Submission ID: 13895

The National Highways Environmental Statement Human Health Baseline and Impacts Sheet 1 of 3 implies a positive health impact in Hatfield Peverel, but this must be considered against the modelling outcomes for Air Quality, which indicates a deterioration of Air Quality at all sensitive receptors including locations along The Street Hatfield Peverel as a result of the scheme, if approved. Read in isolation the Impacts Sheet might lead the reader to wrongly conclude that Air Quality is going to improve when the true overall outcome is a worsening of Air Quality in Hatfield Peverel.

FIGURE 13.3

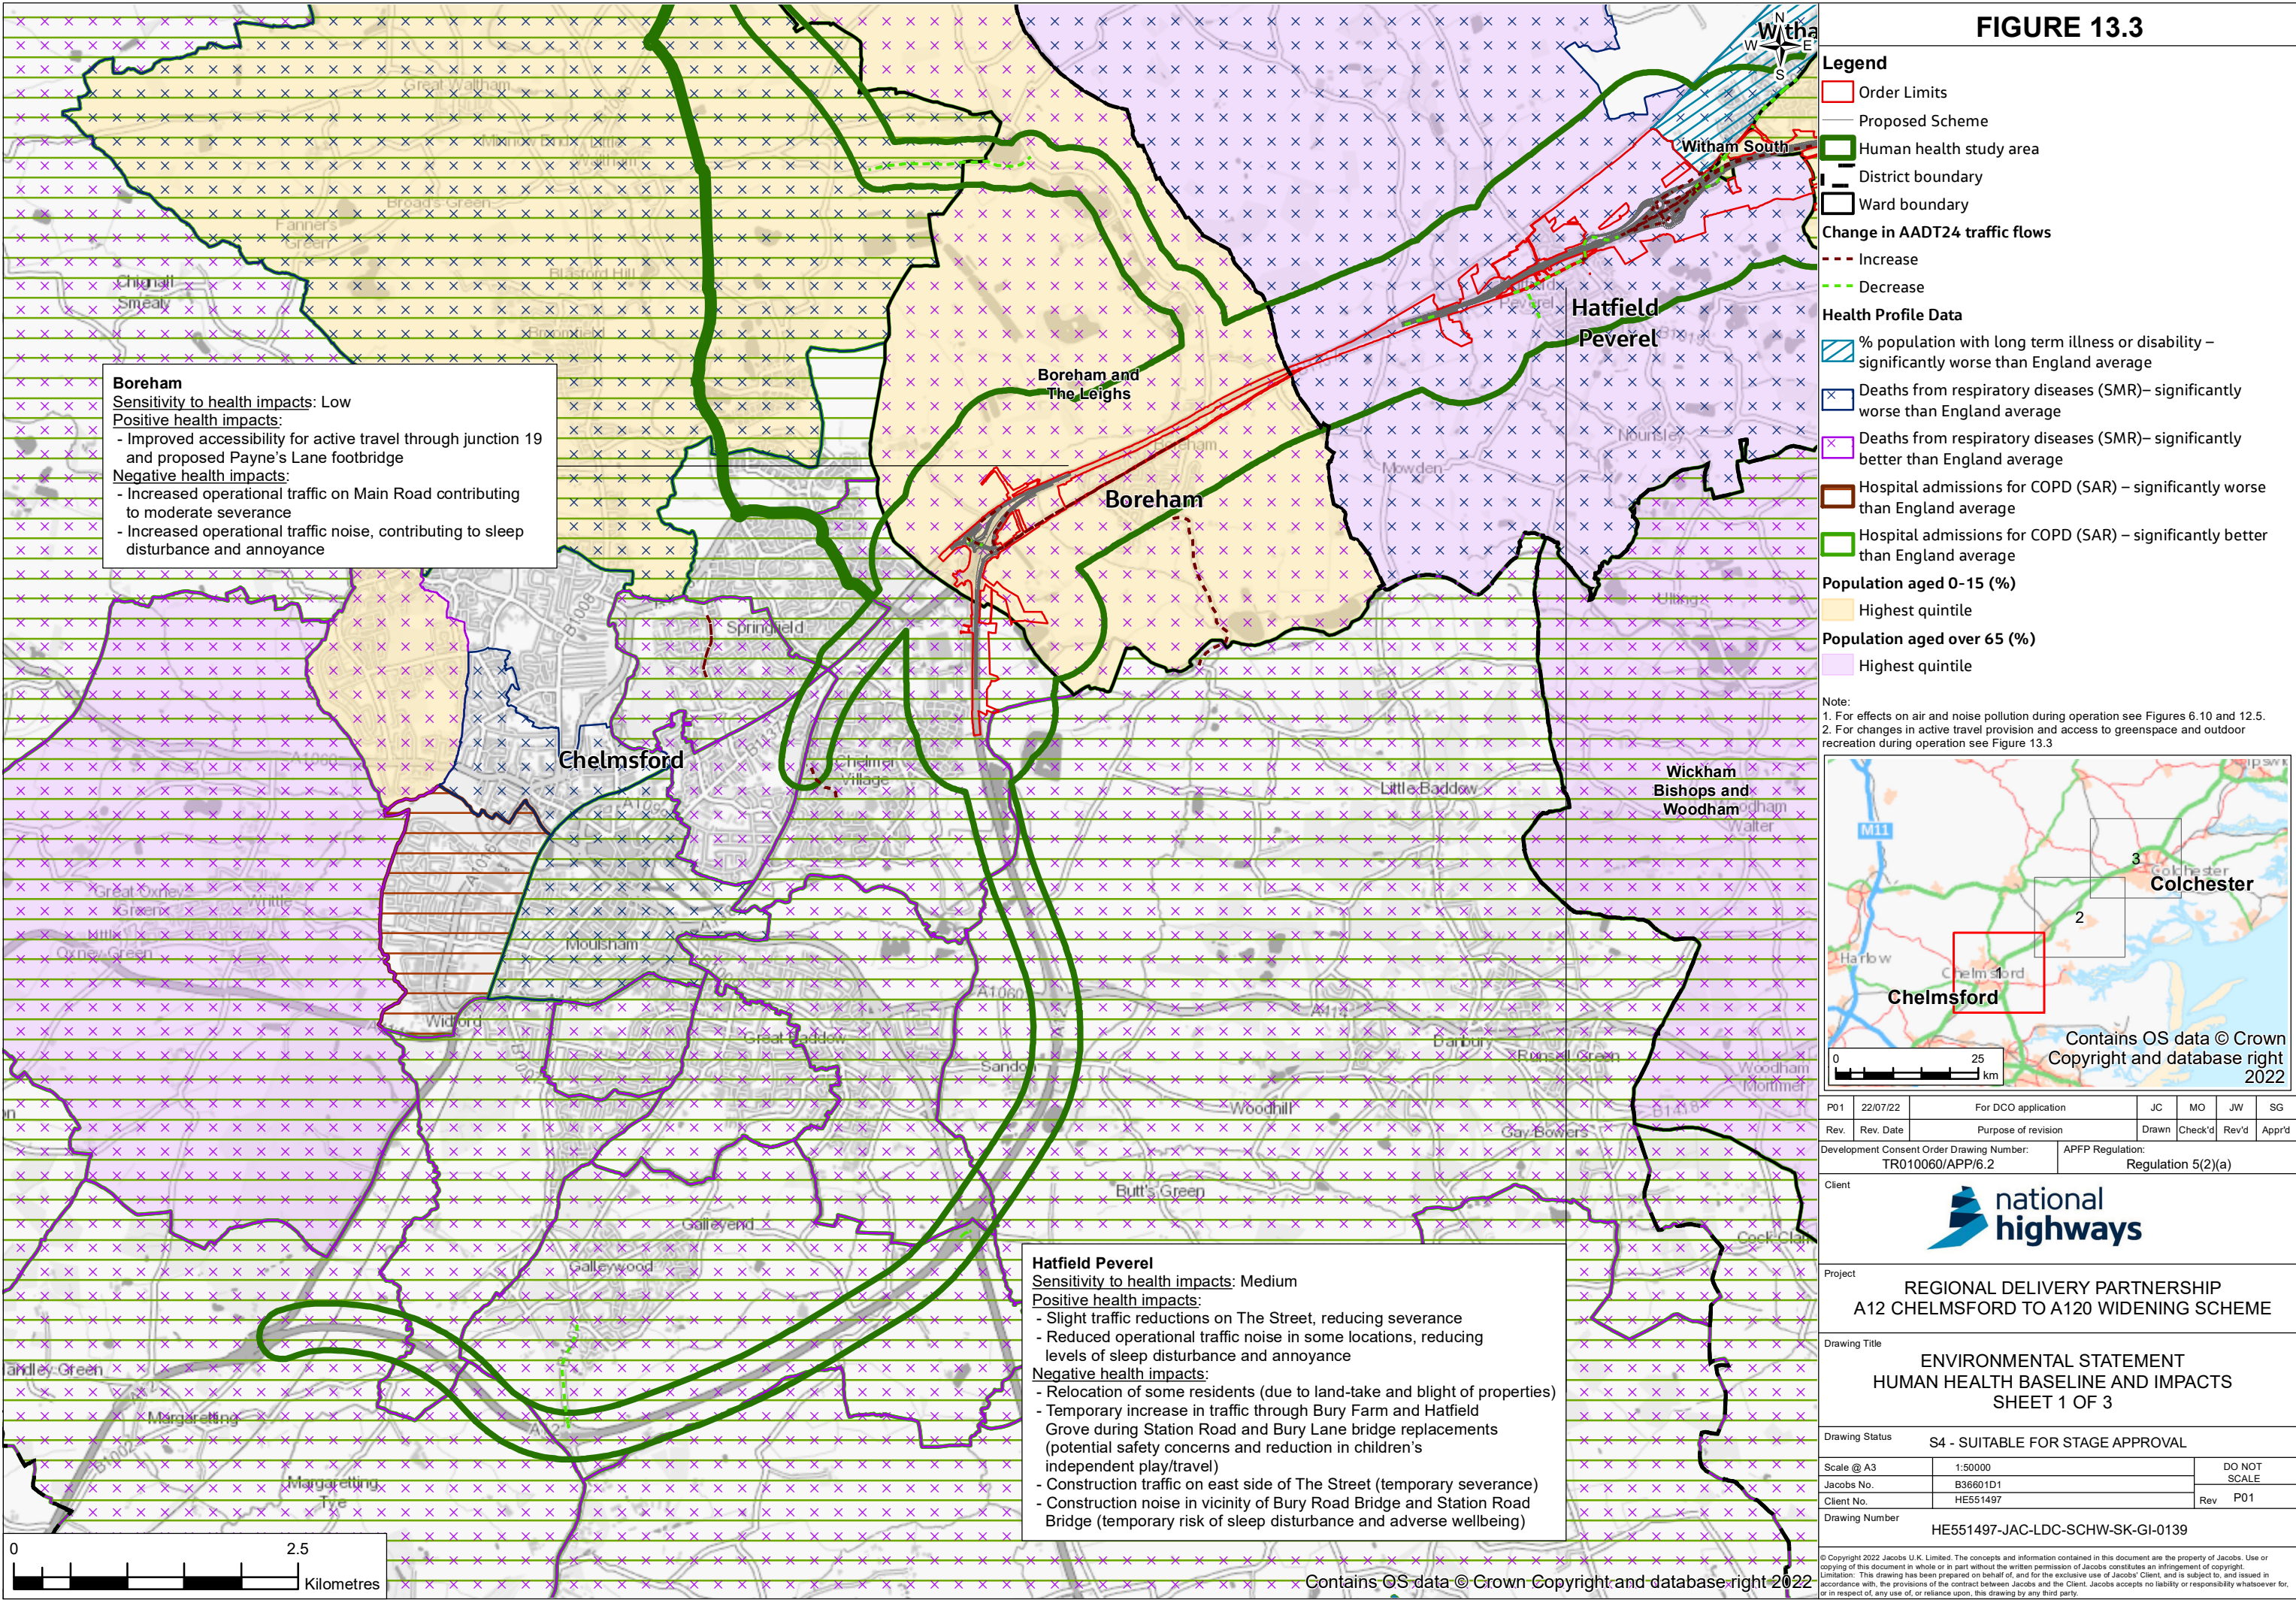
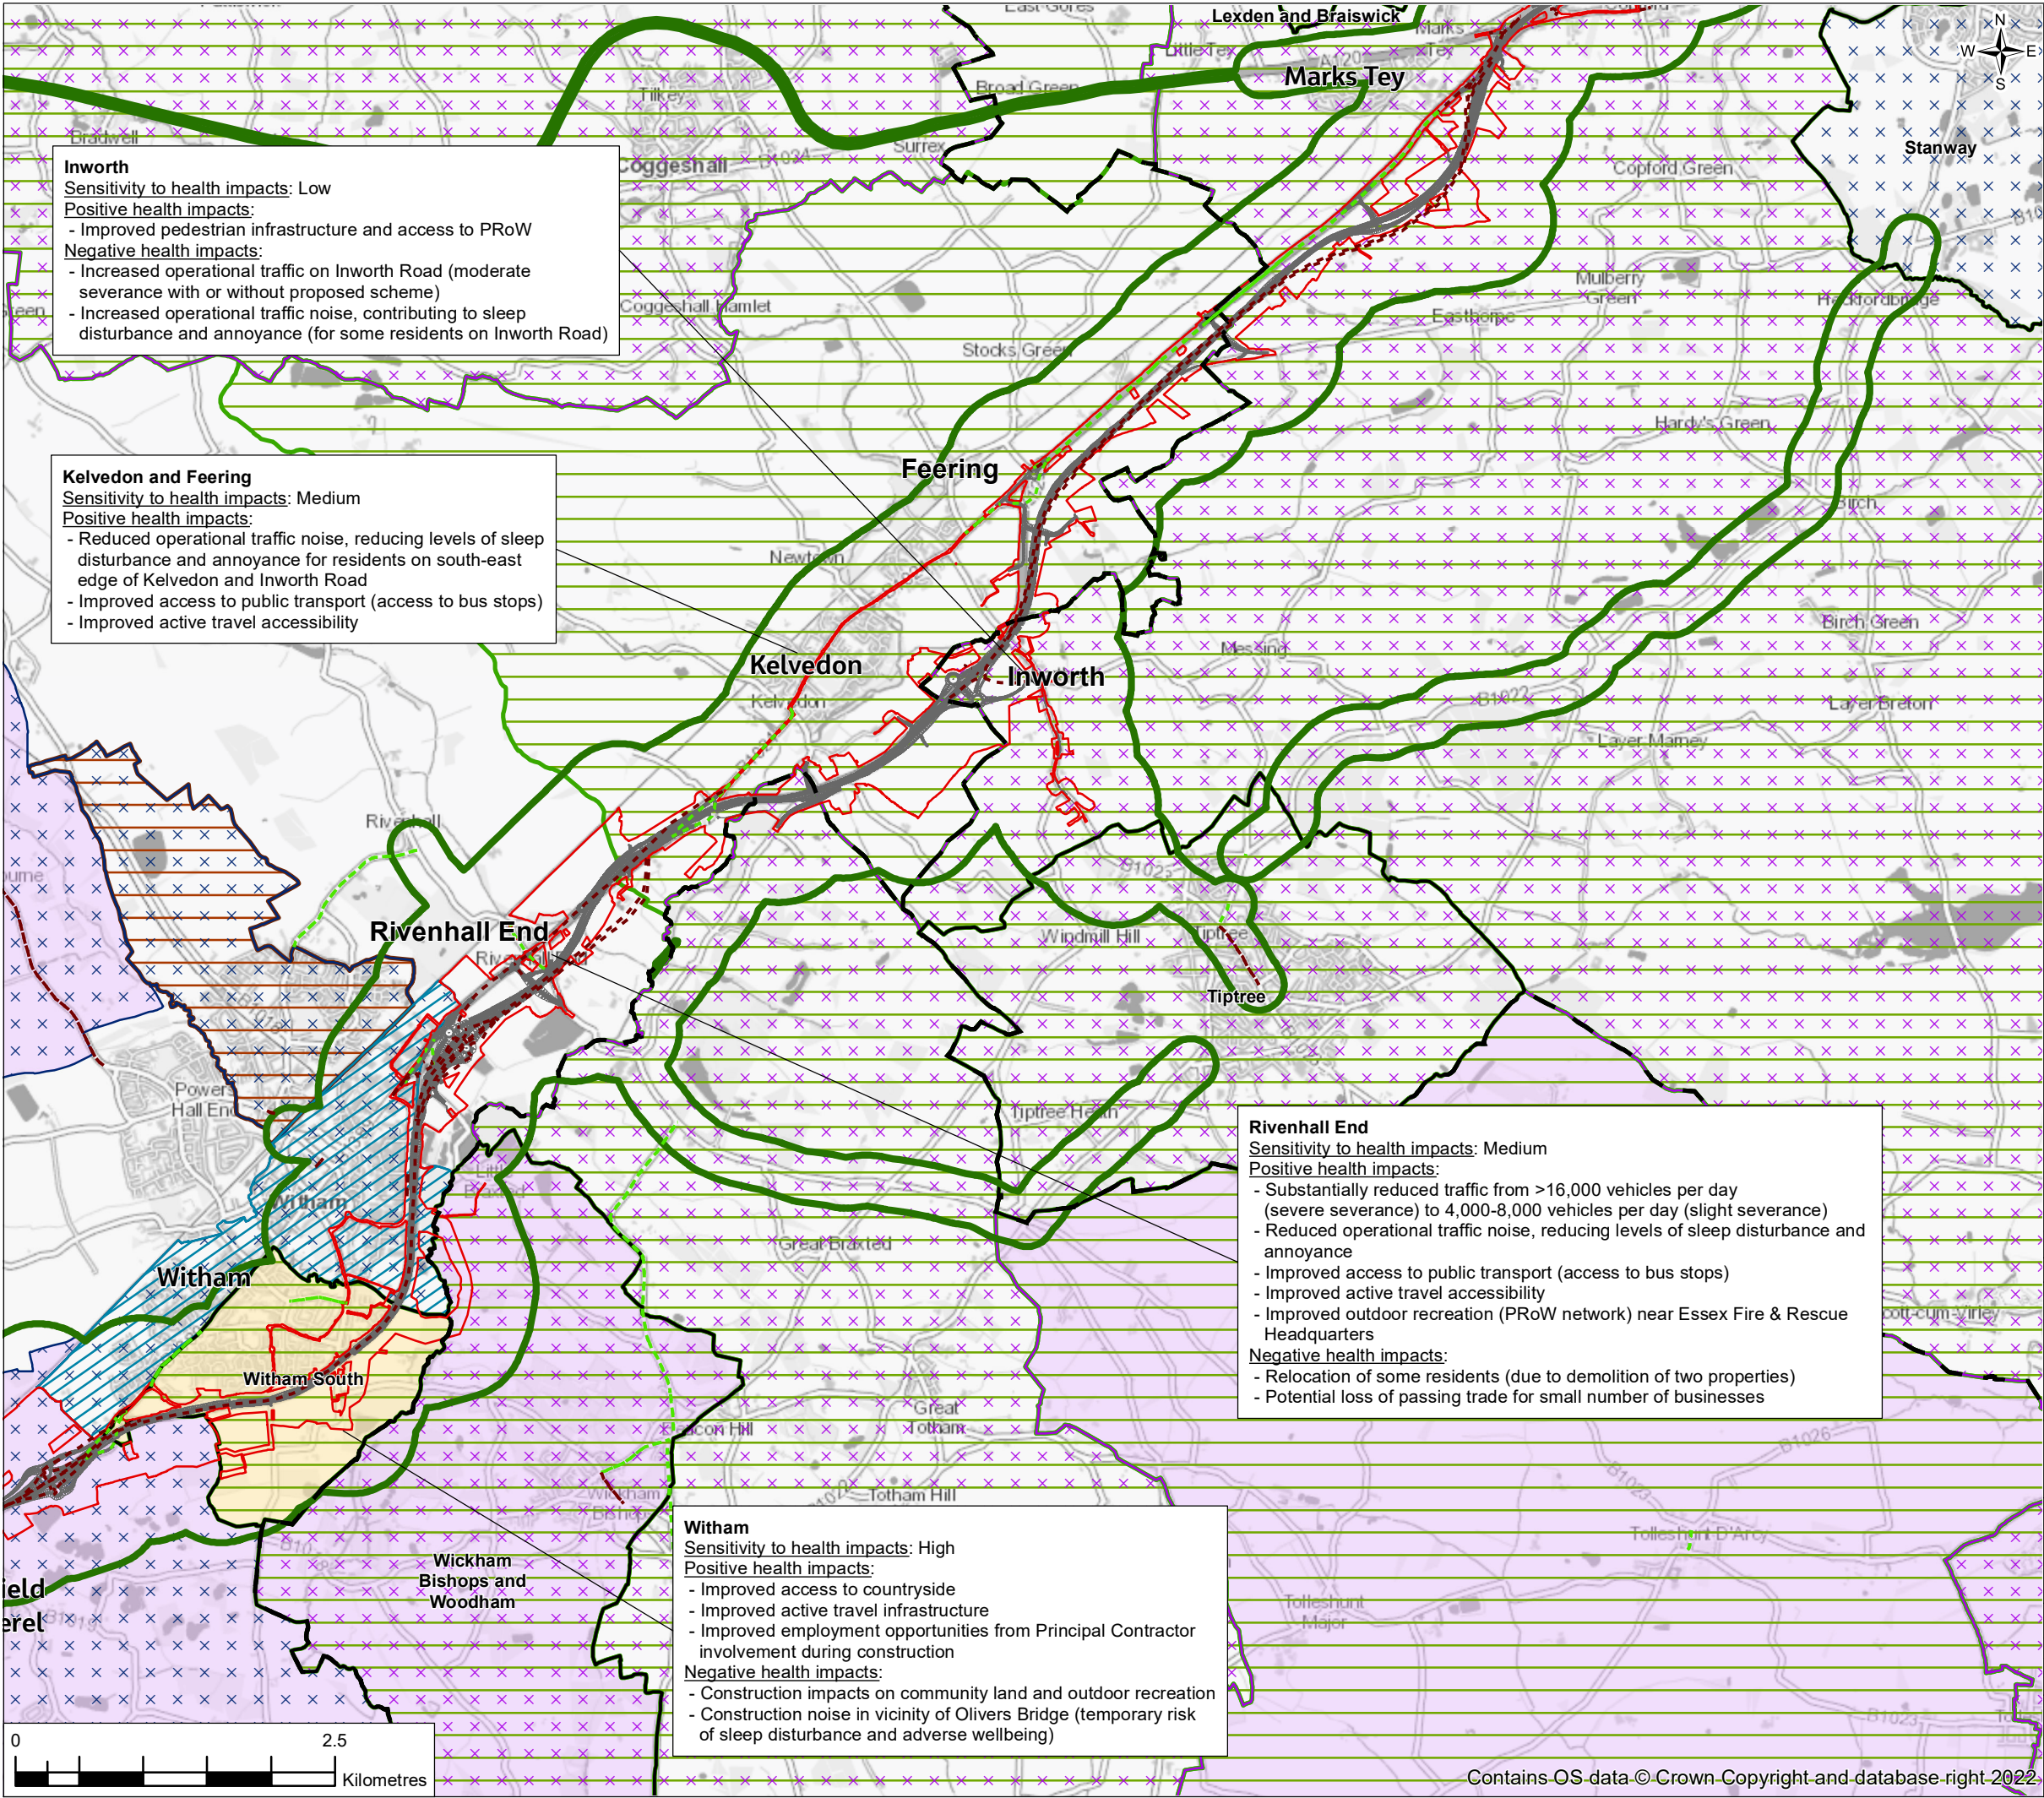
The map NH Health Map provided by National Highways confirms that deaths from respiratory diseases in the parish of Hatfield Peverel is significantly worse than England average and given that National Highways acknowledge through their own modelling that air quality will worsen the position is clearly unacceptable. Furthermore it has been concluded that traffic along Main Road in Boreham will increase yet along the Street Hatfield Peverel they reach the decision that it will reduce. As Main Road and the Street are the same road B1139 it is puzzling how NH could have reached this conclusion.
